RE: Montessori of the Rio Grande Charter School (H12/ D008A)

I am submitting the revised Grading plan for the school addition project. Your review comments of February 2 have been addressed as follows:

C-101

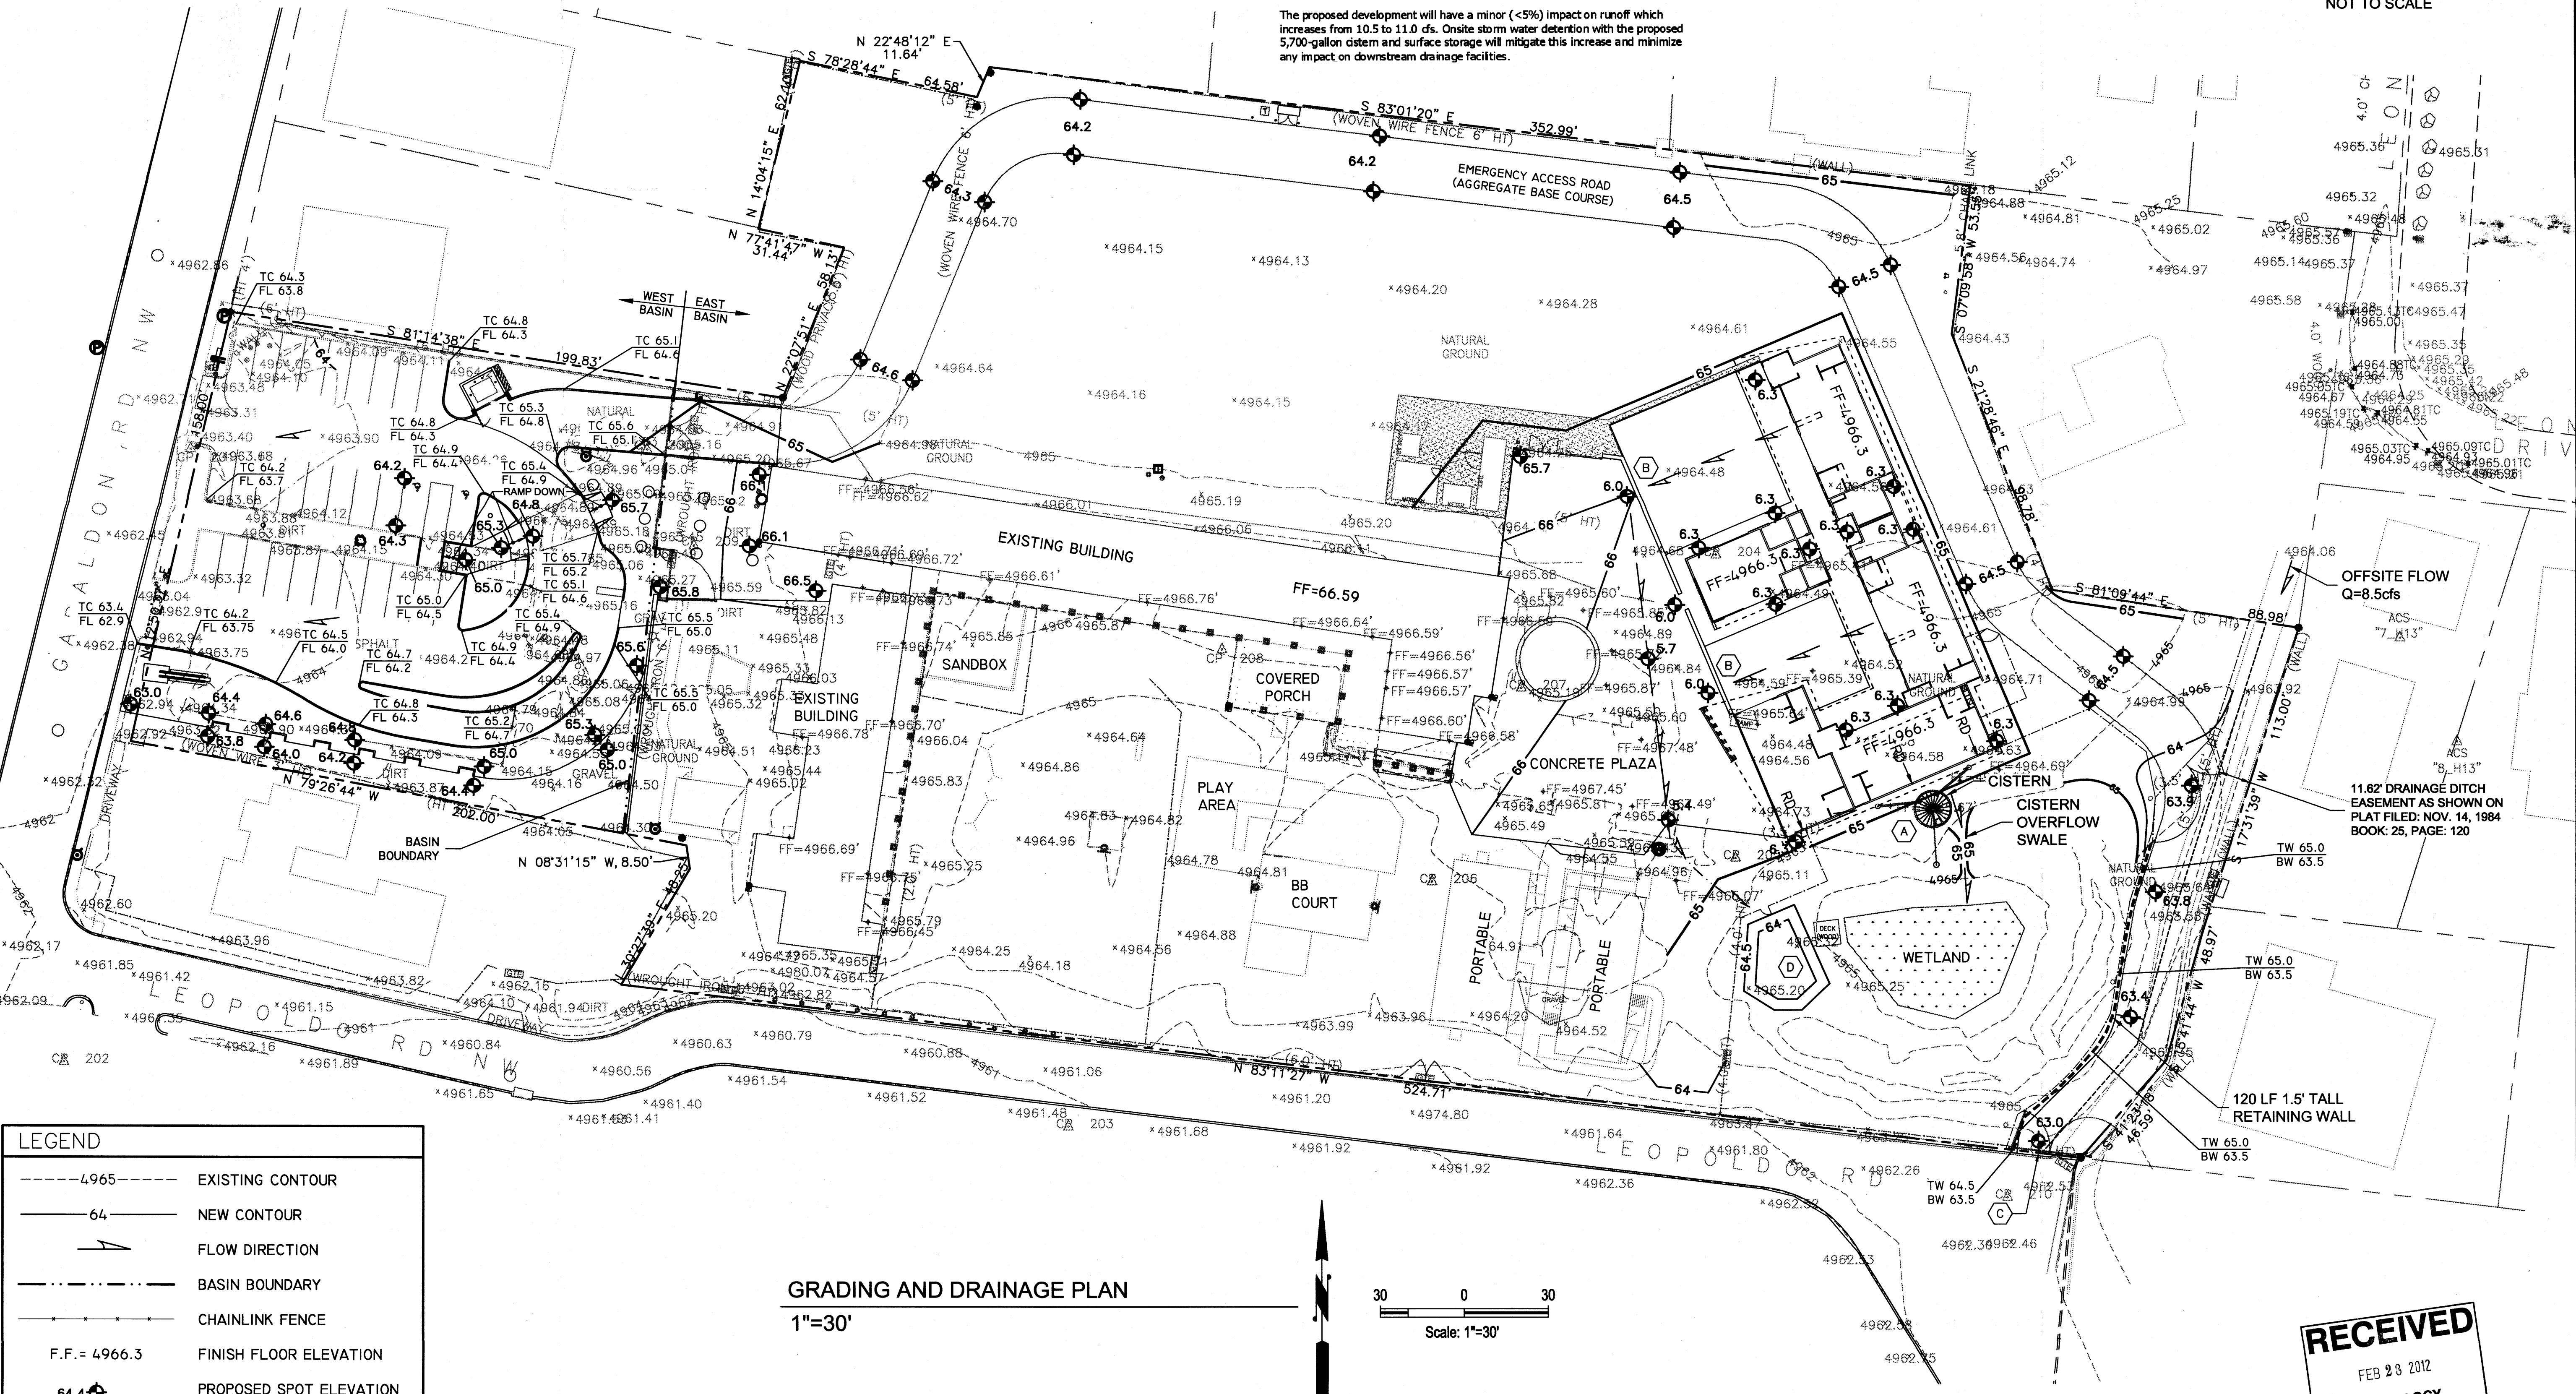
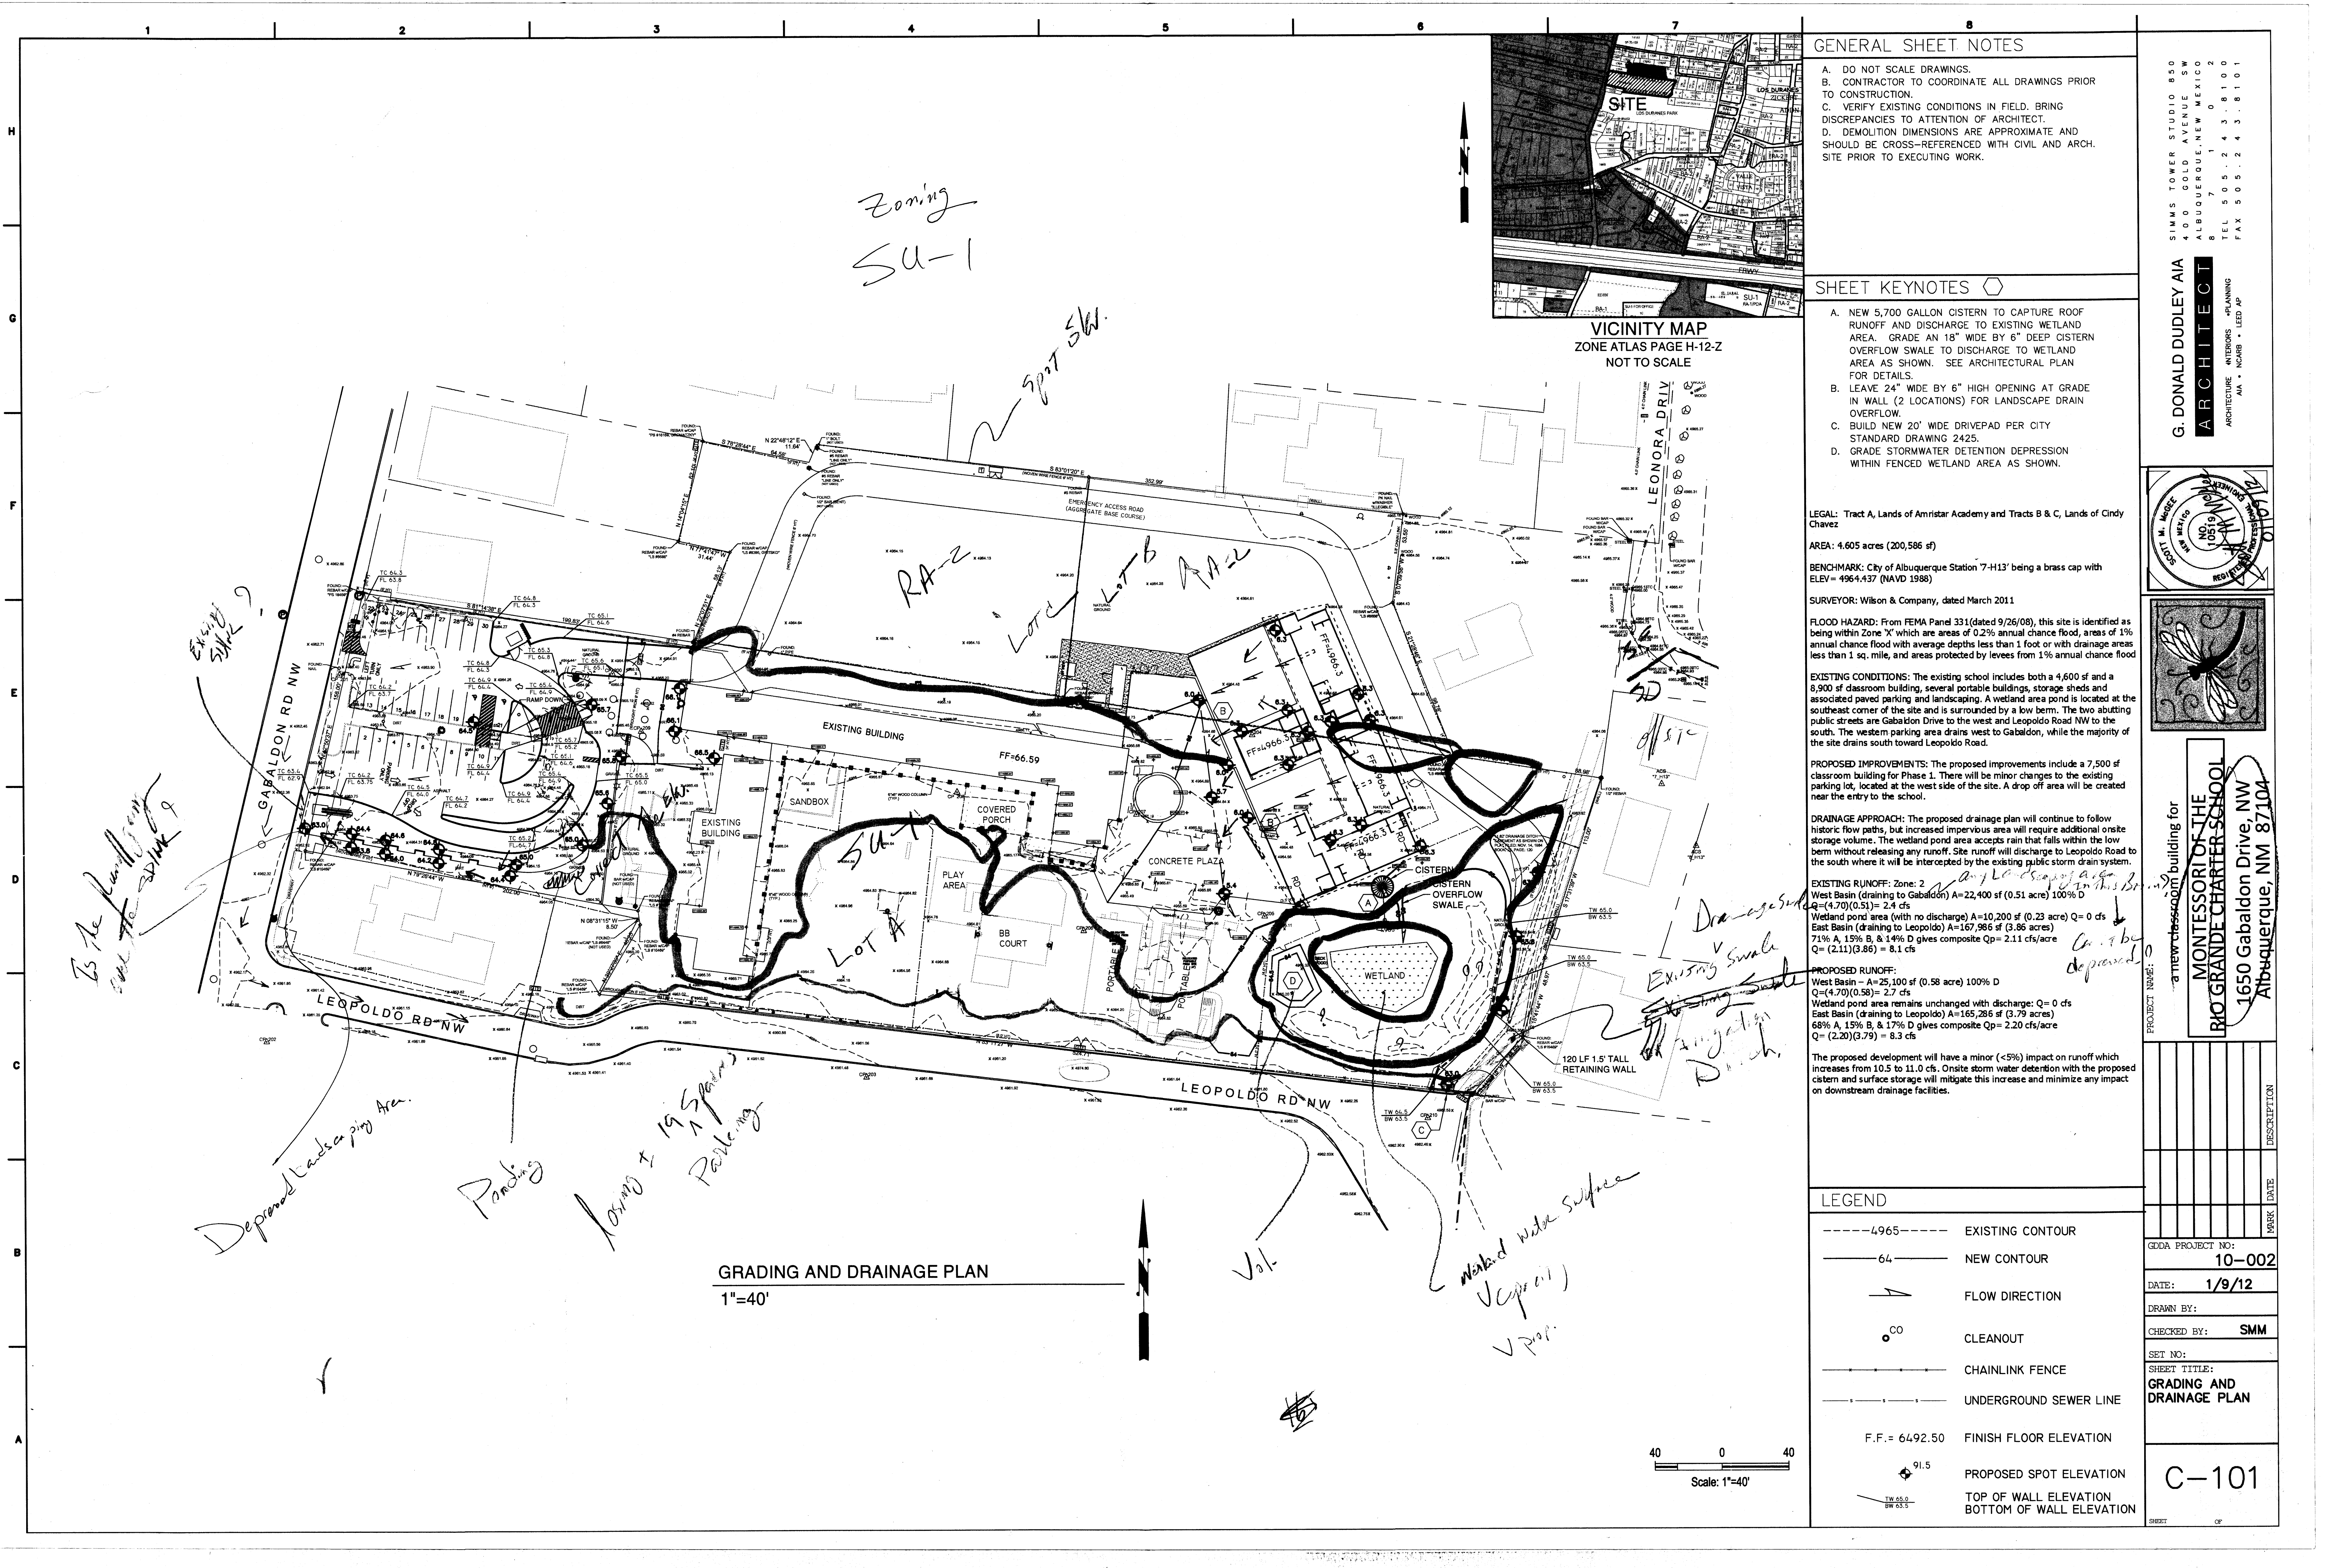
- < The Vicinity Map has been revised.
- < The site is not being replatted or rezoned. The State Board of Education owns the land and is not subject to City zoning requirements.

- < Additional spot elevations have been added.
- < The emergency access road has proposed spot elevations.
- < There isn't an irrigation ditch on the property—MRGCD approval isn't required.

- < Offsite flow enters the property from Leonora and flows along the east side of the site where it exits to Leopoldo Road. The drainage text now addresses this.

- < With respect to impervious area—the change to the west parking is minor.
- < Landscaped areas are existing in the west basin area which limits regrading.

- < The sidewalk south of the parking entry drains west. The landscaping in this area is existing.
- < The spot elevation has been revised.
- < A basin boundary line has been added to the plan.

- < Pond volumes have been calculated and are shown in brackets in the plan text.
